3 August 2012

Section 75W Application Clemton Park Village Concept Plan

We wish to advise that some of the civil drawings have been updated since this Section 75W was originally submitted. A list of plans that have been revised is provided as follows:

Our Ref. 048-11
Dwg File Ref. [Rev.] - Sheet Ref.
048-11C_E300-306 [02] - 305

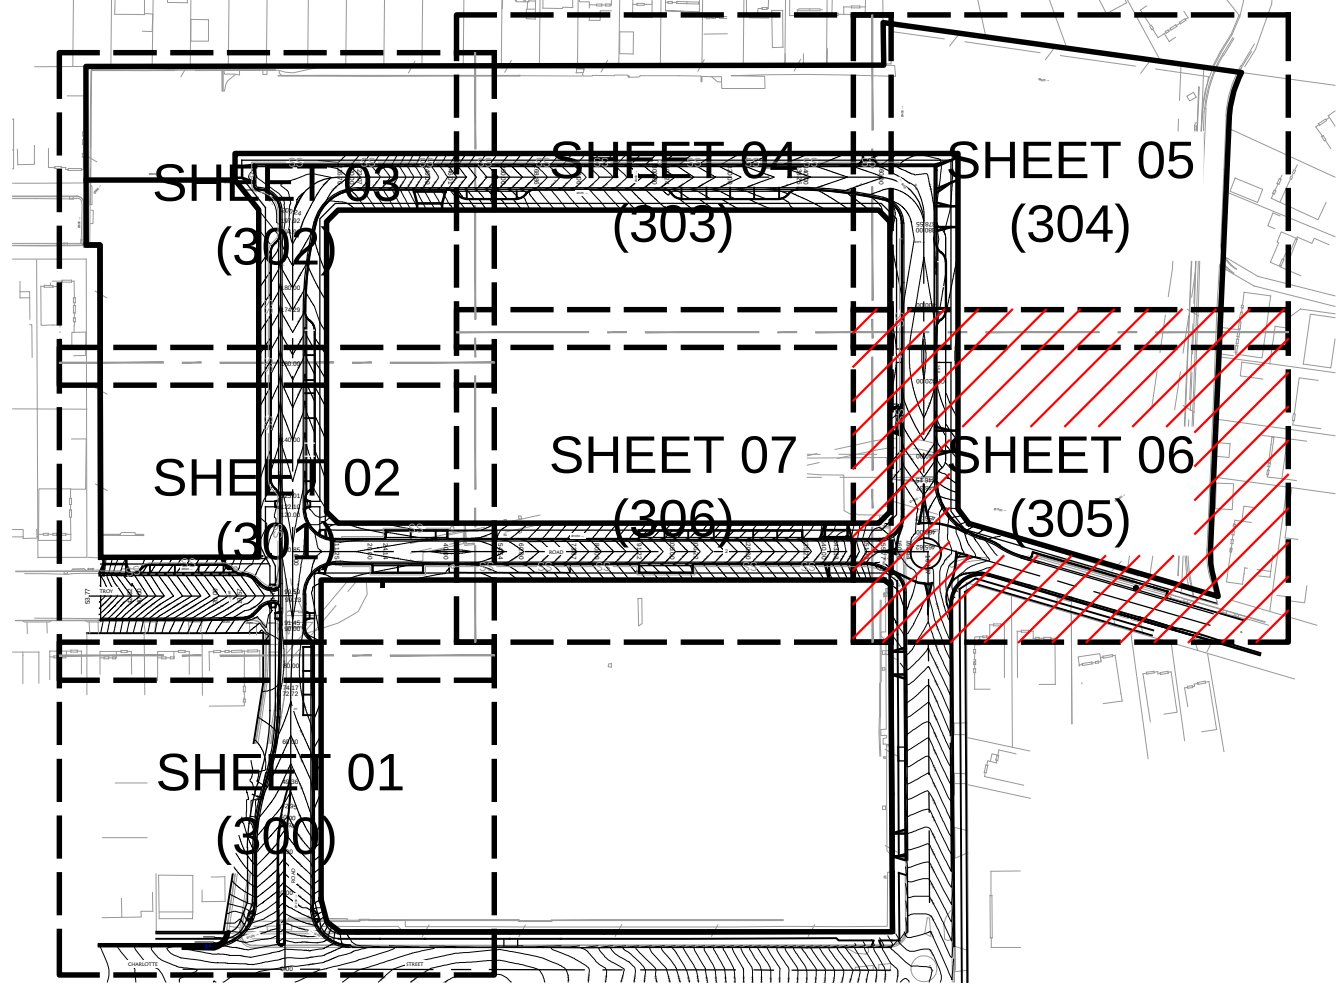
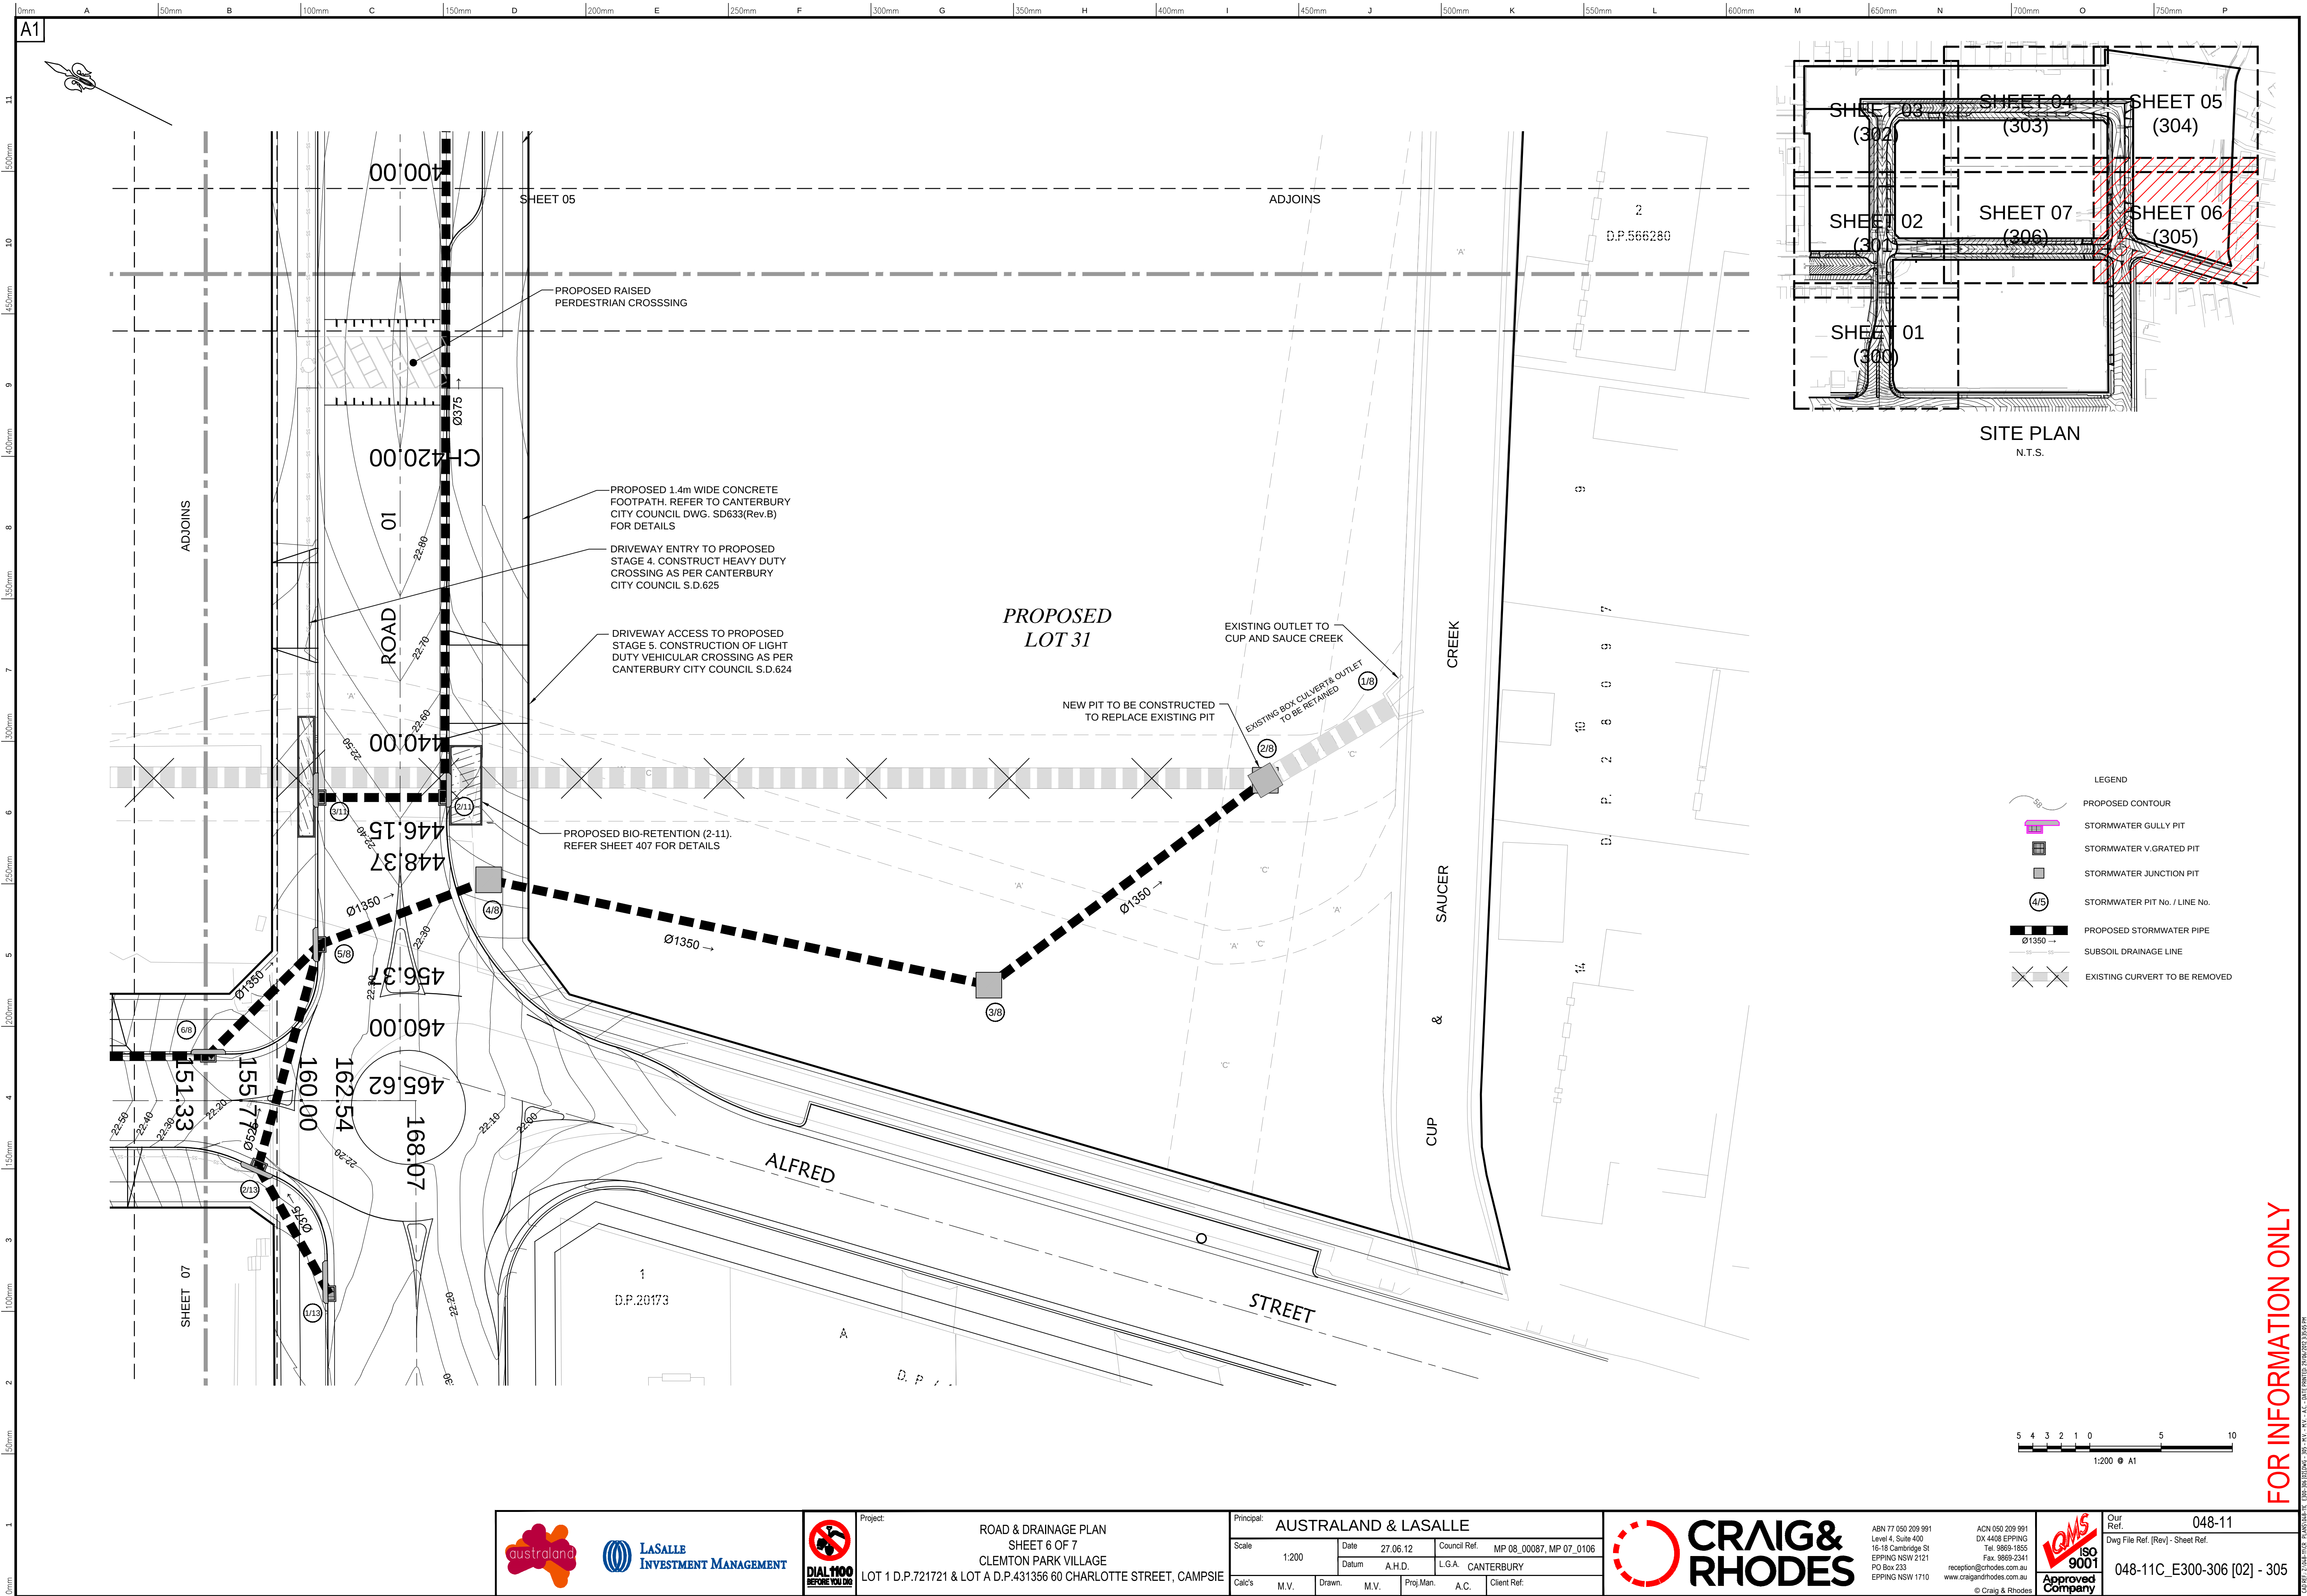
- 103: Added details for raised median at Eastern End of Road 1
- 105: Added details for Troy Street Pavement
- 305: Added details for raised pedestrian crossing on Road 1
- 315: Details for raised pedestrian crossing, special raised road surface treatment, roundabout centre island & splitter islands added
- 403: Stormwater Line 5 added
- 404: Stormwater Line 5 added
- 604: Services Plan Sheet 4 added
